# KITTITAS COUNTY DEPARTMENT OF PUBLIC WORKS

## MEMORANDUM

SUBJECT: B & T Short Plat

B & T SHORT PLAT
PART OF SECTION 2, T. 20 N., R. 14 E., W.M.
KITTTAS COUNTY, WASHINGTON

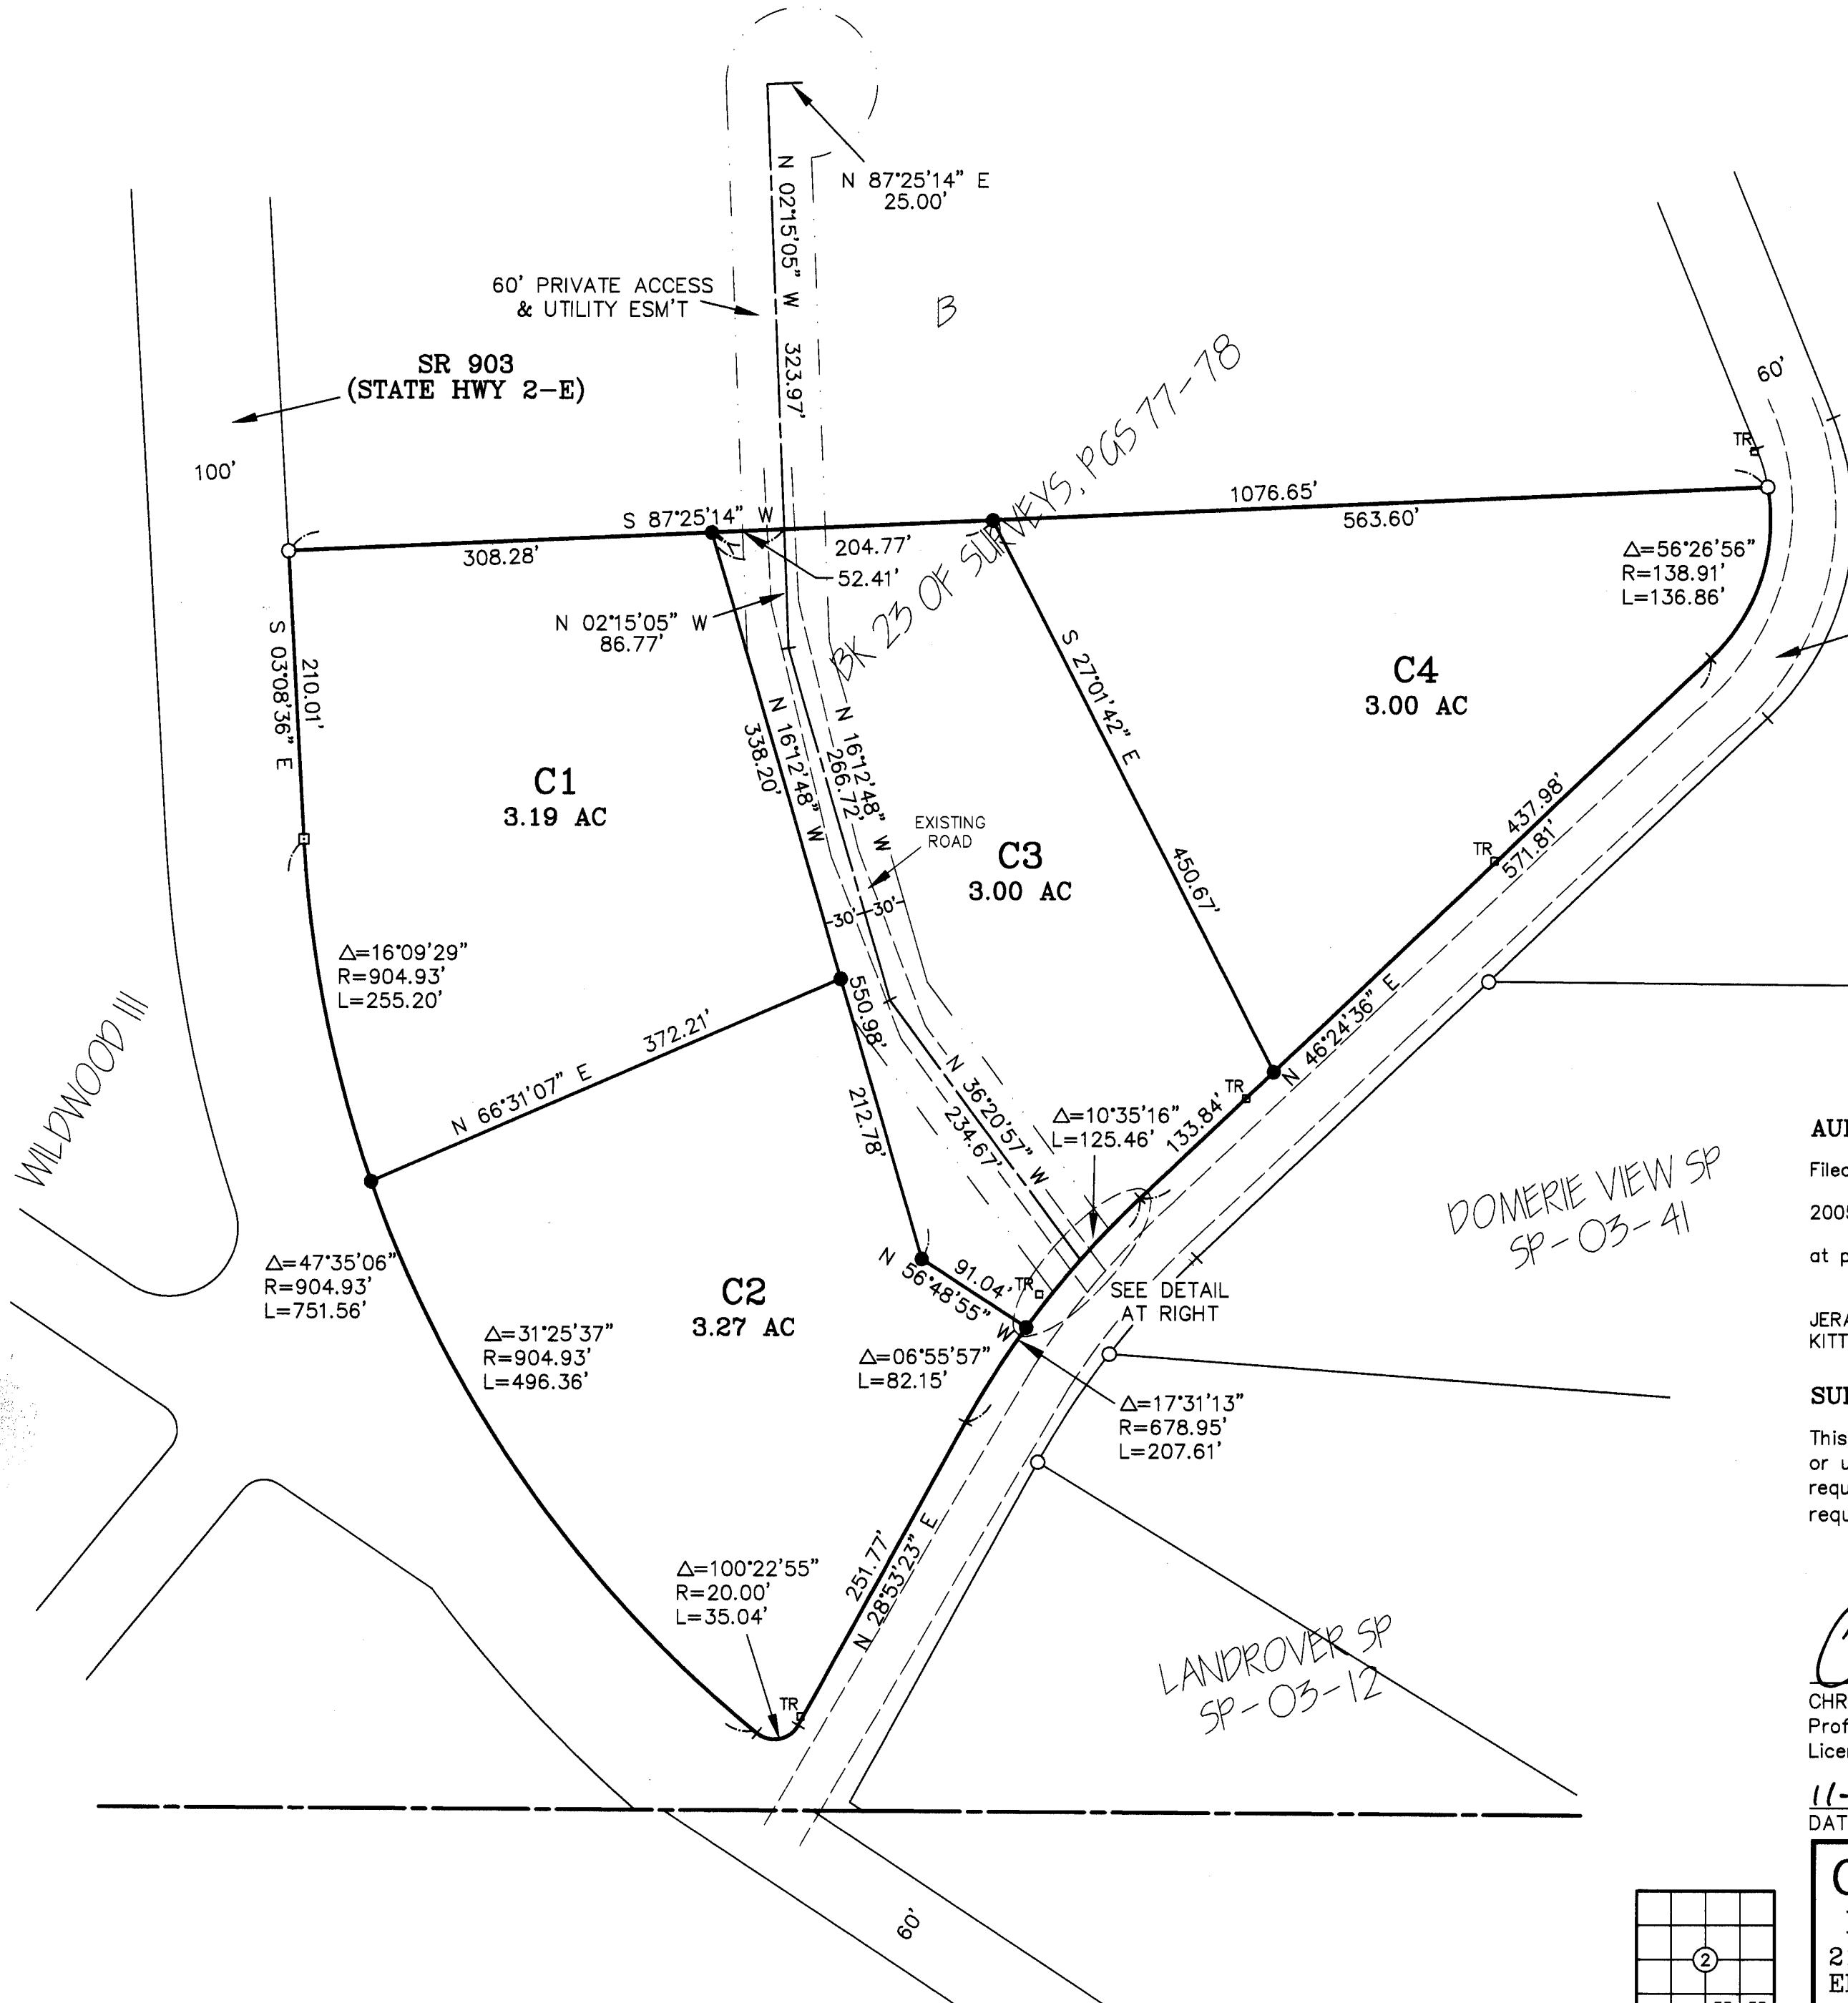
3. Cul-de-sac for High Density Private Road: Typically a cul-de-sac is required with easement shown providing adequate turn around for the parcels on the plat. B & T Short Plat does not reflect any cul-de-sac at the northern boundary line. A temporary or permanent easement shall be shown on the face of the plat to provide for the cul-de-sac.

Lot C1 access is restricted to the private access easement. Access will not be approved off SR 903. **Plat Note**

Lot C2 access is restricted to the private access easement or Tom Write Mine Road. Access will not be approved off SR 903. **Plat Note**

The AFN Number for the 60' private access easement shall be shown on the face of the plat. **Update Plat**
